**WELWYN HATFIELD BOROUGH COUNCIL
EXECUTIVE DIRECTOR - PLANNING, PUBLIC PROTECTION AND GOVERNANCE**

Application No: 6/2017/2664/LAWP
Location: Manor Cottage Vineyards Road Northaw Potters Bar EN6 4PQ
Proposal: Certificate of Lawfulness for the erection of 2x single storey side extensions, erection of outbuilding and the installation of dormer widow
Officer: Mr David Elmore

Recommendation: Refused

7 Outbuilding layout
1 : 200

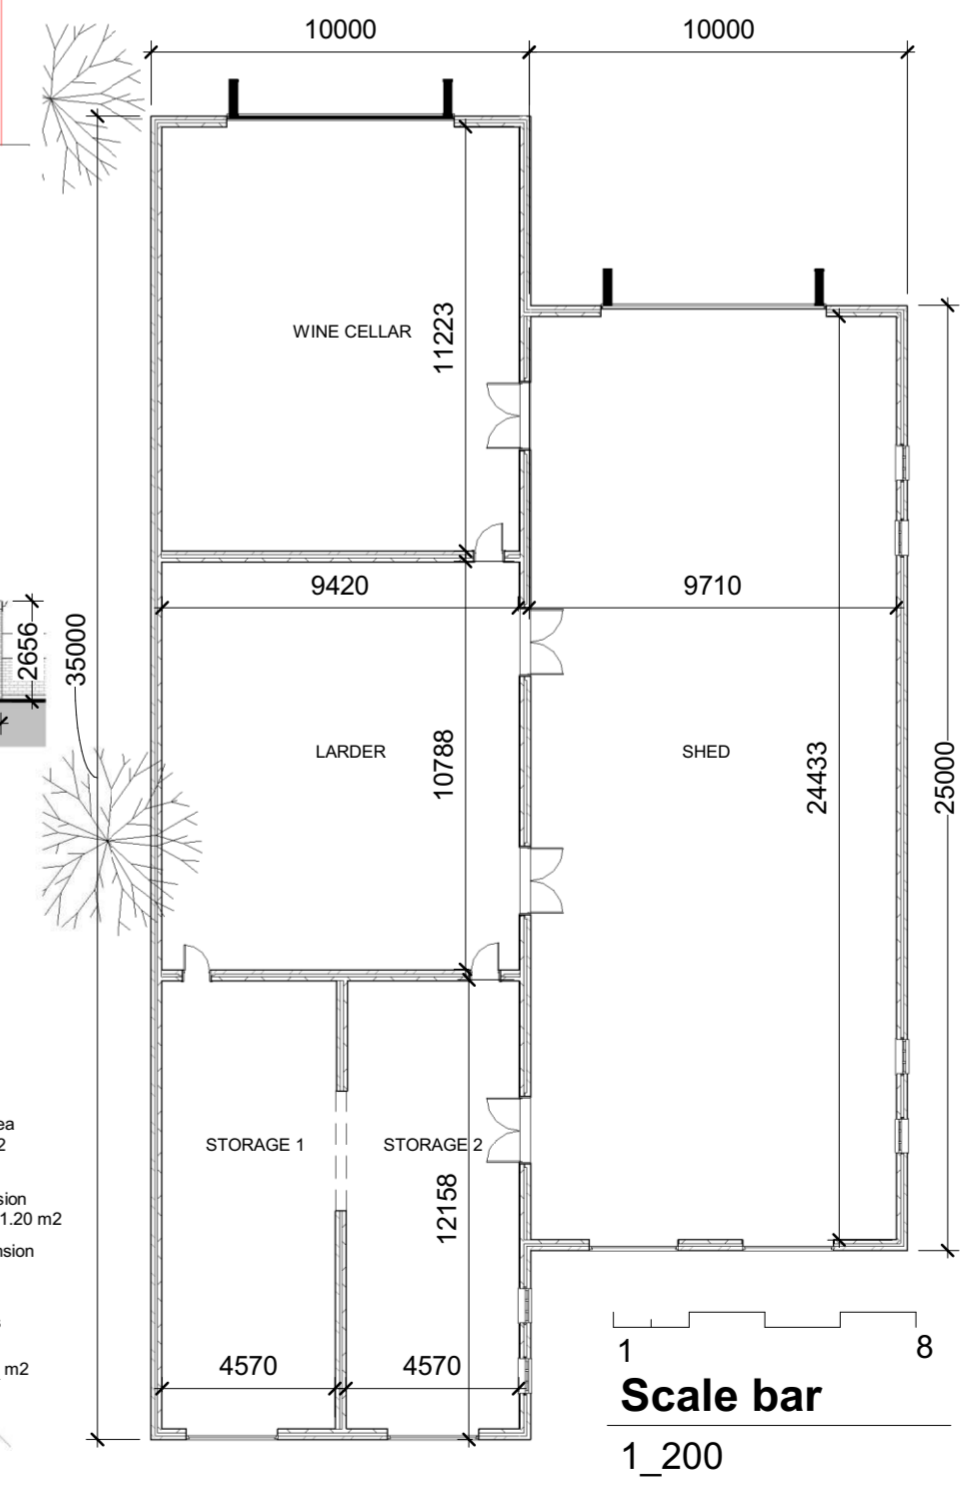
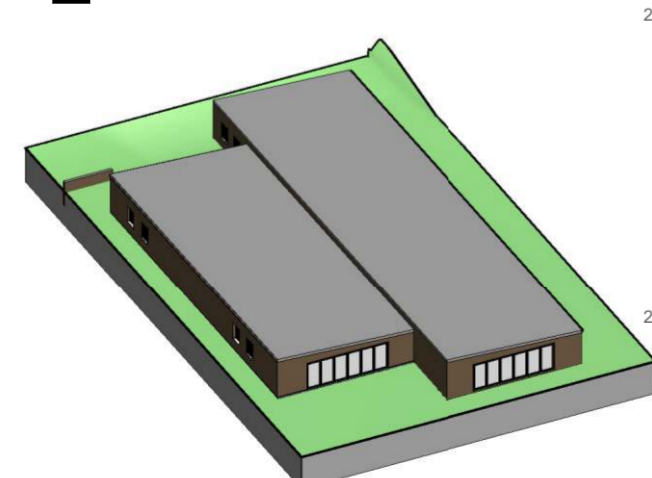
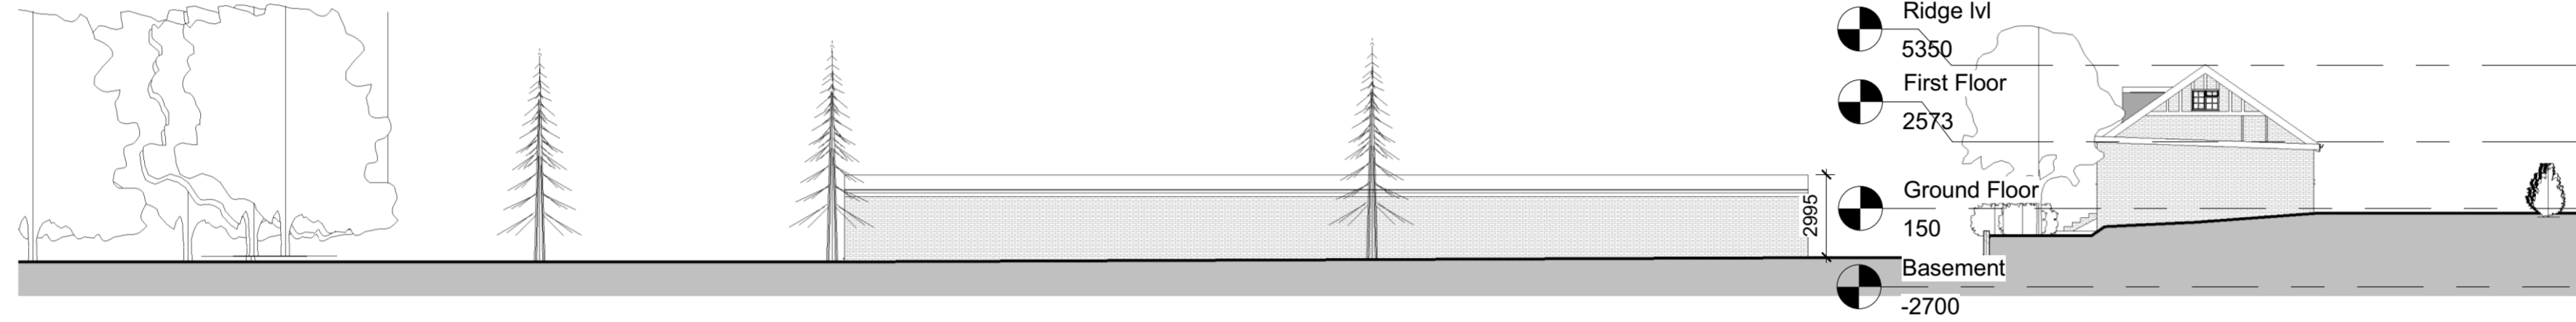
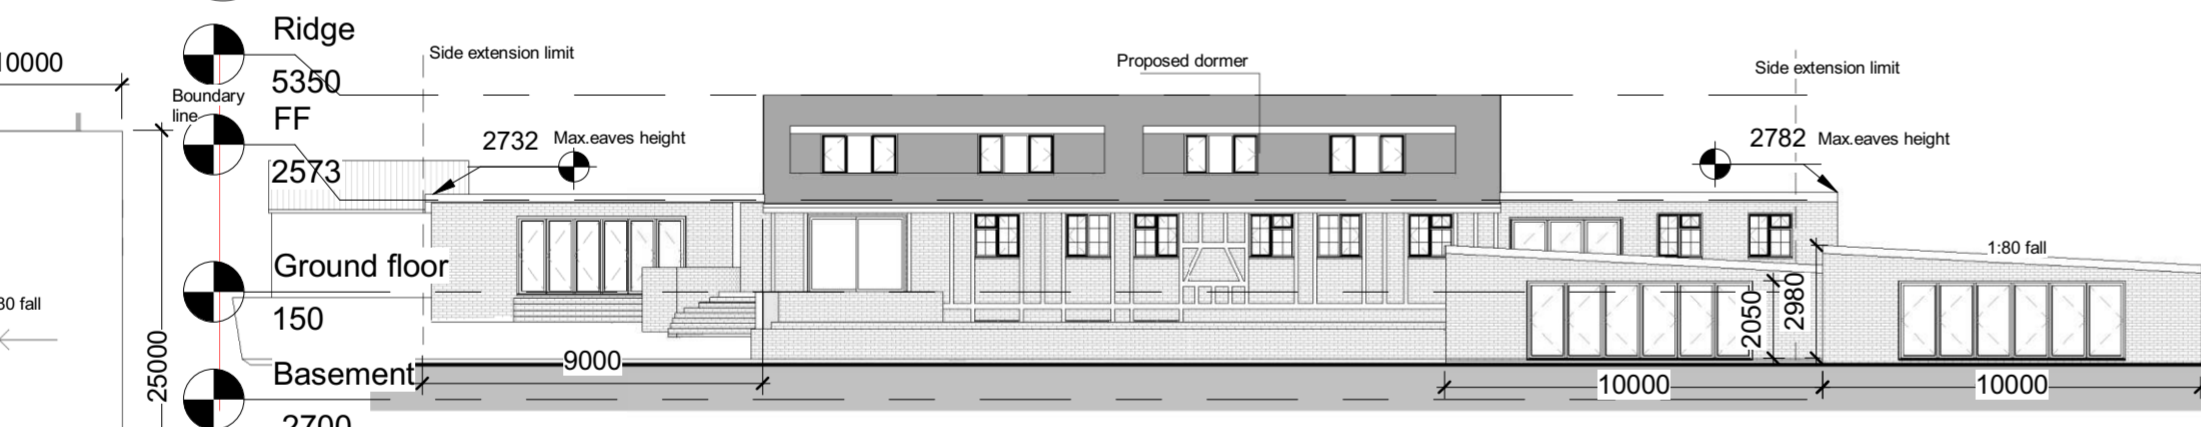
(j) the capacity of the container would exceed 3,500 litres.	N/A	N
<u>Whether the outbuilding is incidental to the enjoyment of the dwellinghouse?</u>		
<p>There is no statutory definition of the word “incidental”. However, case law provides authority for how this should be interpreted by decision makers. In the leading case of <i>Emin v SSE</i> [1989] it was held that it was wrong to conclude that an outbuilding could not be said to be required for a use reasonably incidental to the enjoyment of a dwellinghouse as such because it would provide more accommodation for secondary activities than the dwelling provided for primary activities. Nevertheless, the test must retain an element of objective reasonableness and should not be based on the unrestrained whim of an occupier: <i>Wallington v SoS for Wales</i> [1990]; <i>Holding v FSS</i> [2004]; <i>Croydon LBC v Gladden</i> [1994]. On the other hand, a hard objective test should not be imposed to frustrate the reasonable aspirations of a particular owner or occupier so long as they are sensibly related to the enjoyment of the dwelling. These judgments and the findings therein serve to illustrate that with each case it is a matter of fact and degree based on the particular circumstances: <i>Peche d’or Investments v SSE</i> [1996].</p> <p>The proposed outbuilding would be situated in the rear garden of the application and measure 1200sqm. It would serve a very large wine cellar, shed and larder together with average two storage rooms. This outbuilding would be more than double the footprint of the existing dwelling which is substantial.</p> <p>The size of the wine cellar, shed and larger would be more than double the footprint of what is already a large chalet style bungalow. This is way in excess of what could be considered reasonably required as an incidental use for this 4-bed single family dwelling.</p>

4. The proposed outbuilding, by virtue of its size and the scale and extent of the facilities it would accomodate, would not be reasonably required for a purpose incidental to the enjoyment of the dwellinghouse. Therefore, this aspect of the proposal would fail to comply with Schedule 2, Part 1, Class E of the Town and Country Planning (General Permitted Development)(England) Order 2015 as amended.
